**REQUEST**

Current Zoning: O-3 (office)  
Proposed Zoning: MUDD-O (mixed used development, optional)

Approximately 9.94 acres bound by the south side of Fairview Road, east side of Piedmont Row Drive South, and the north and west side of Barclay Downs Drive.

The petition proposes redevelopment of parking decks and modifications to existing development to accommodate additional mix of uses including residential, medical office and retail in addition to the existing EDEE use and office buildings on the site in South Park.

RZ-101

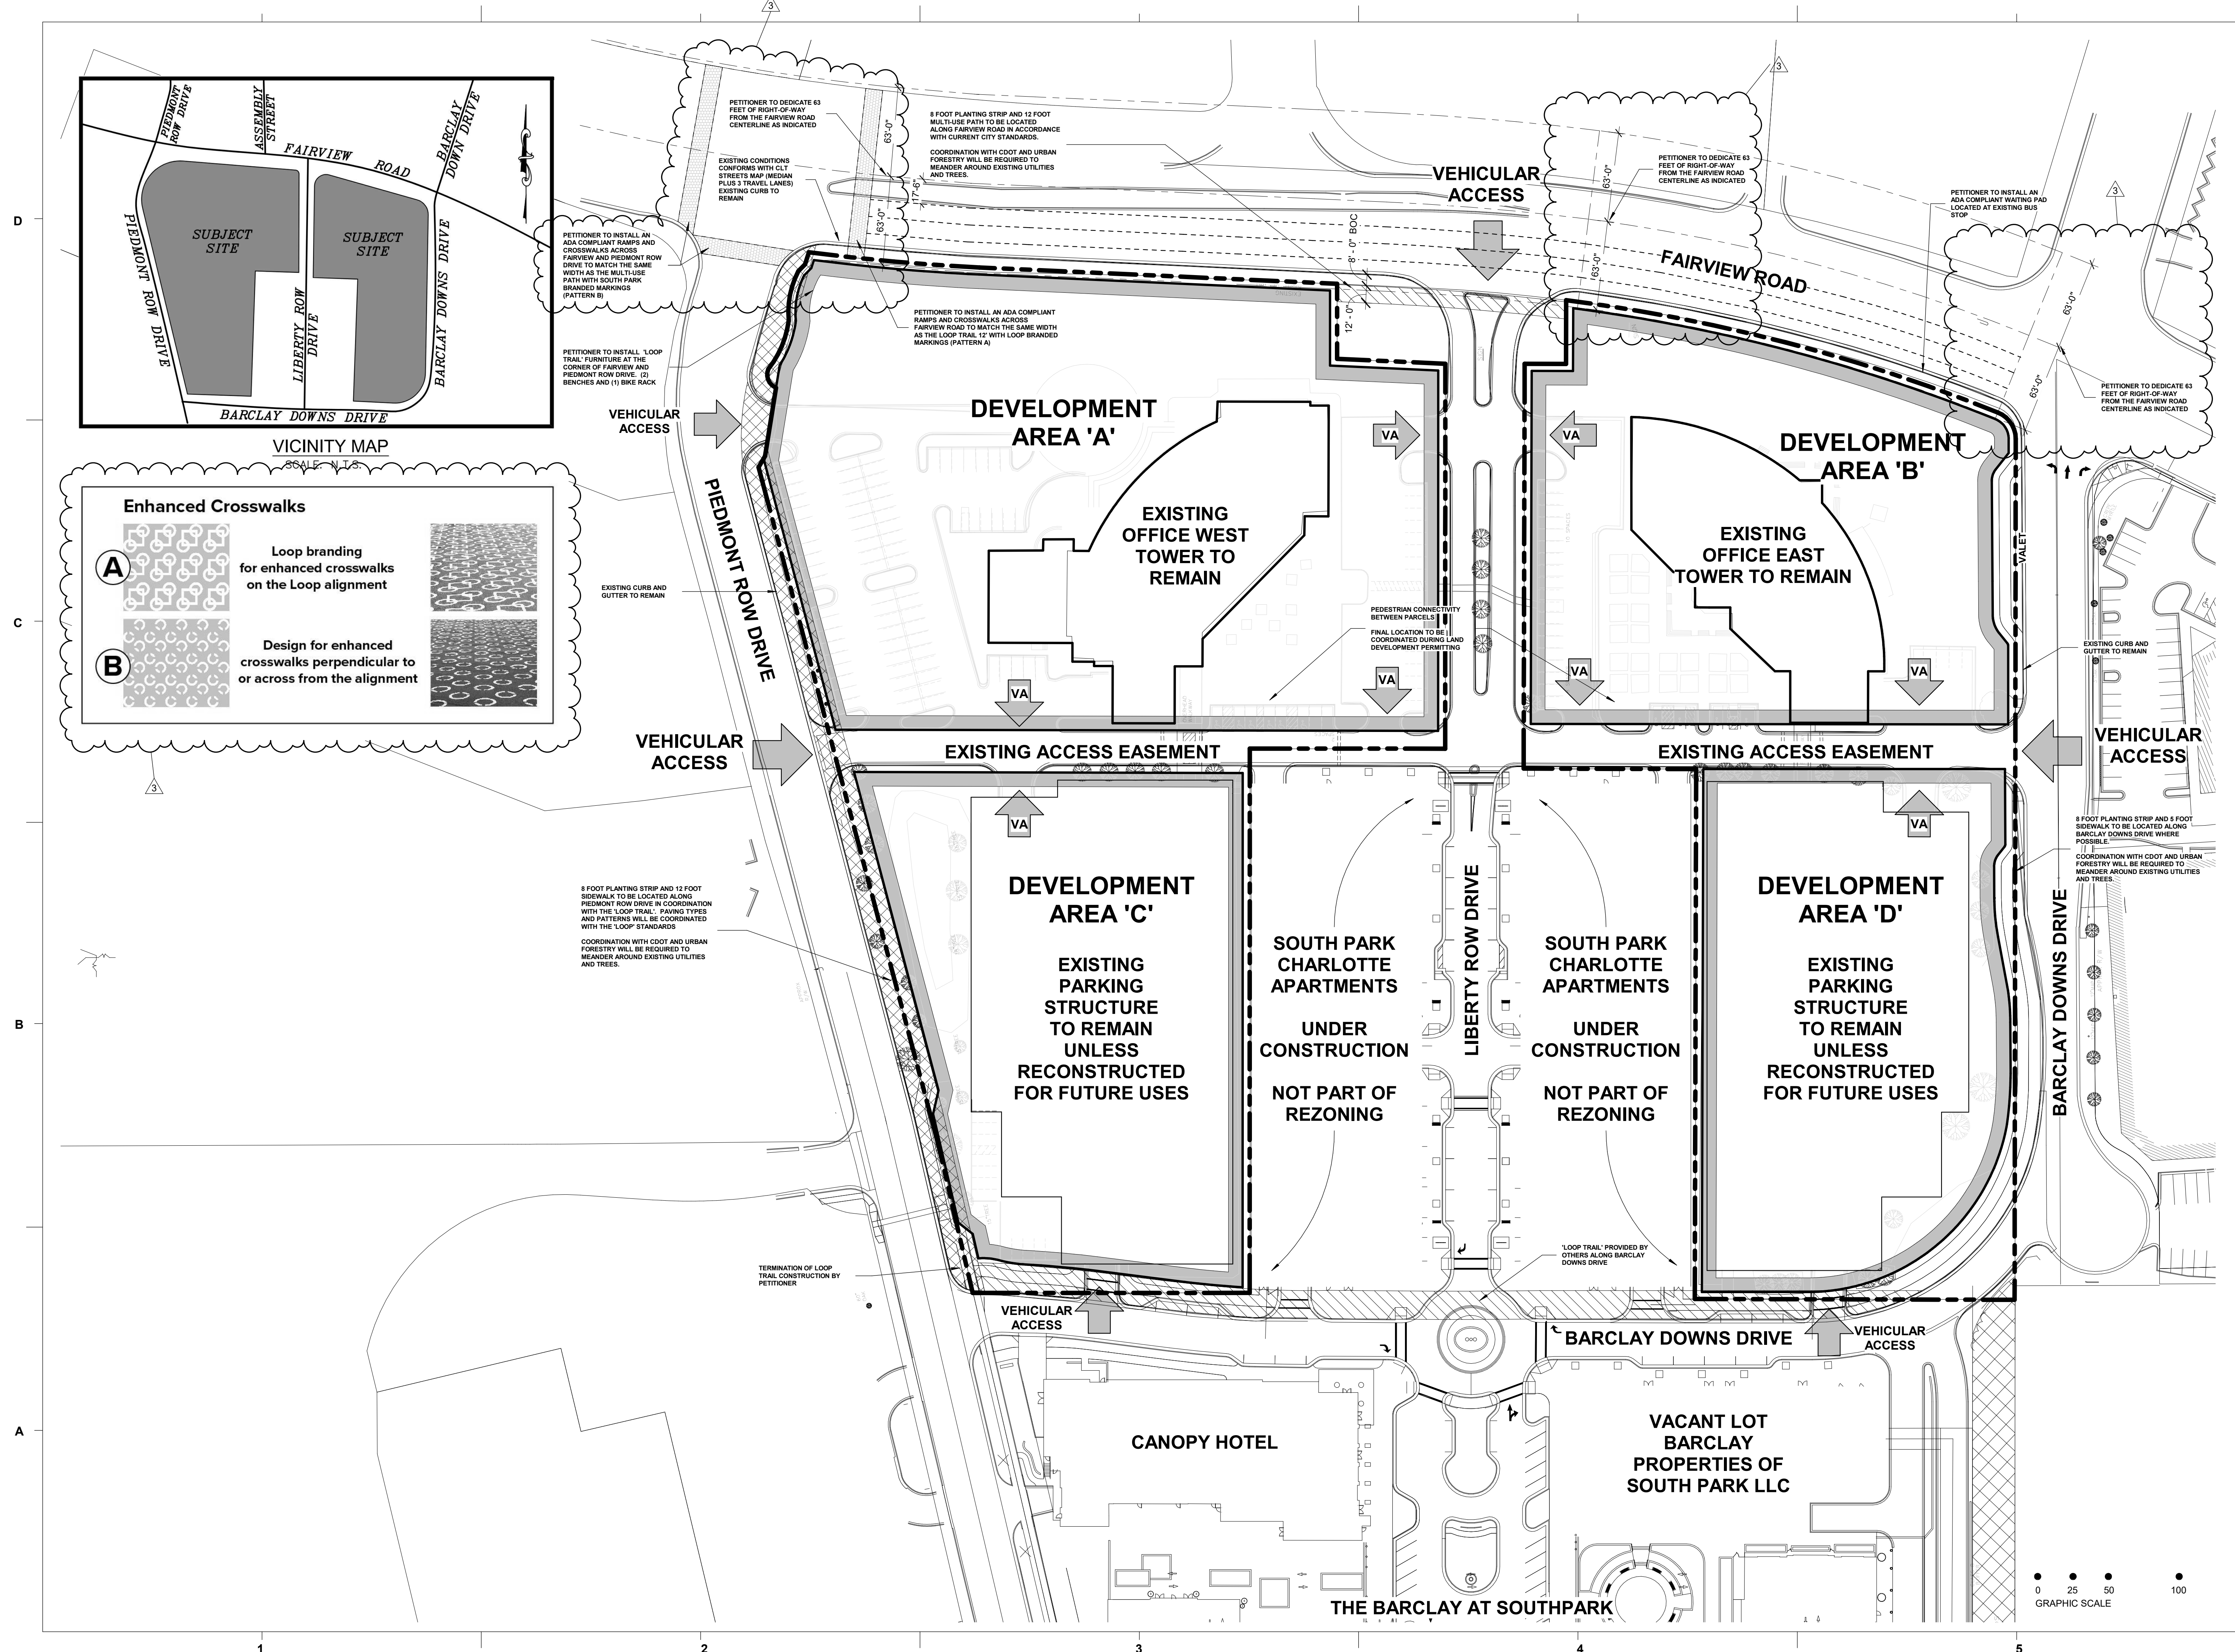
3. ~~Design standards are inadequate. If the petitioner does not want to incorporate new UDO standards, reference and incorporate standards from RZP 2020-059 as a baseline.~~ Addressed
4. Amend Design guideline note b.7 to specify a building height in feet for stepbacks rather than stories.
5. Amend references to "primary building façade" throughout the design guidelines and use "elevations facing public rights-of-way" or define primary building façade and highlight locations on the site plan.
6. Remove or amend the last sentence of Transportation note V.d. related to trigger Loop commitments.
